Designing out Crime Report Addendum

Ref: 028-2-2021 MR

For: [20/01224/RM](#)
[Land Abutting Cayton Village Caravan Park, Mill Lane,
and Cayton](#)

Date: 20 January 2021

SITE LAYOUT LAYERS KEY:

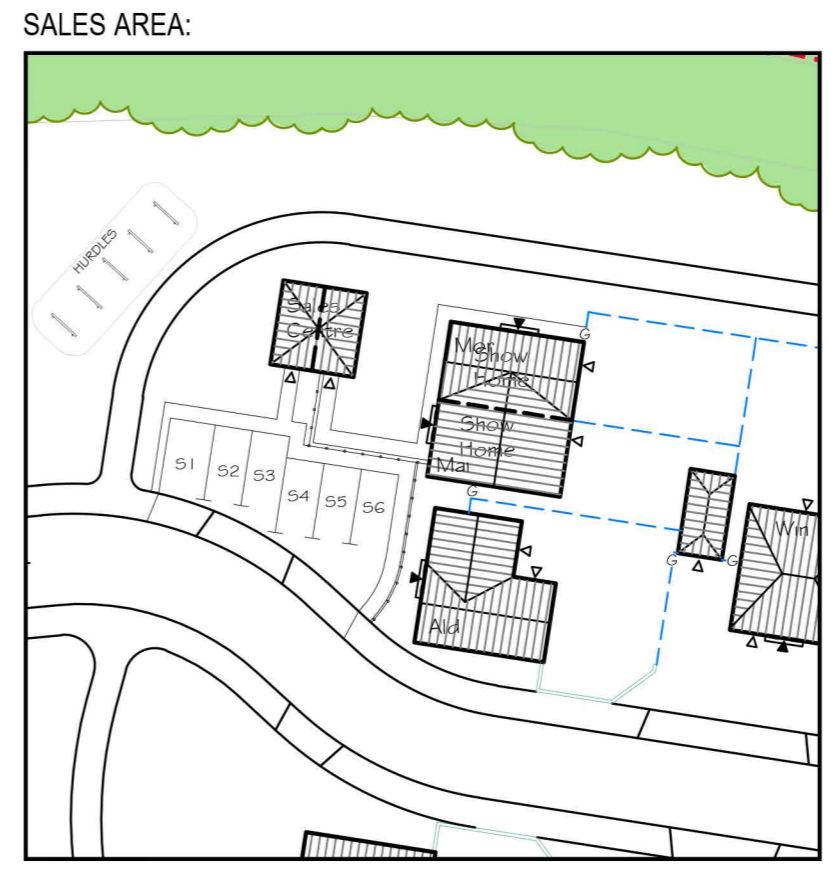
- 4.3.3 However, I have some concerns in relation to the footpath to the north of the site that runs to the rear of Plots 3 to 6, the Quarter housing and to the side of Plots 9 & 10. Public footpaths should not run to the rear of properties. Research has shown that providing access to rear gardens or yards can generate crime and anti-social behaviour. It can also leave the rear of the property vulnerable, by providing criminals with the opportunity to attempt to gain access to the rear gardens whilst being unobserved.

- 4.3.4 This footpath does not appear to serve any purpose, such as providing access to local amenities and therefore consideration should be given to either removing it from the scheme, or redesigning the layout so that dwellings are reoriented to face the footpath.

- 4.3.5 It is noted that the entrance to some of the units forming the Quarter housing is to the rear, where they are not overlooked. This has the potential to increase the fear of crime of residents and visitors to these units, especially as there is the footpath running to the rear as highlighted in paragraph 4.3.4 above.

- 4.3.6 It is also noted that there is a footpath link running between Plots 51 and 52, which again lacks overlooking from the adjacent dwellings due to a lack of fenestration in the side elevations. Consideration should be given to including a window in the side elevation of these properties from an “active room²”

4.6.4 There is an example of this type of feature between Plots 48 & 49 as shown in the below figure

4.7.1 It is pleasing to see that in general there is demarcation to clearly identify defensible space to house frontages. However, there is a lack of physical demarcation between the public realm and the frontages of Plots 14 and 65 to 67.

4.7.2 There are also a number of locations where a climbing aid has been created, which would assist an offender to be able to gain access to the rear garden, leaving the rear of the property vulnerable to criminal attack. These can be found at Plots 3, 9 and 10 where the 450mm knee rail abuts the boundary treatment to the rear garden and Plot 49 where the low wall is adjacent to the 1800mm fencing.

4.7.6 The knee rail that provides physical demarcation between the public realm and semi-private space around Plots 19 to 22, would benefit from being supplemented with hedging, similar to that used for the area around Plots 15 to 18. This would prevent persons being able to enter the semi-private space around these units by simply stepping over the knee rail, and may assist in increasing the feeling of safety for the residents and their visitors.

- 4.8.3 To prevent disputes over indiscriminate parking, details of what the provision for visitor parking will be should be provided, as the submitted drawings only appear to show one designated visitor parking space, which is between Plots 72 and 73. This is supported by BHL, which states that developers should anticipate realistic levels of car parking demand, to guard against displaced and anti-social parking

4.7.3 One possible solution in respect of Plots 3, 9 and 10 would be to replace part of the knee rail where it abuts the boundary fencing with a section of hedging used in that location, as shown in the red line in the below figure.

4.7.4 A possible solution in respect of Plot 49 would be to introduce a transition panel, such as that shown in the below figure.
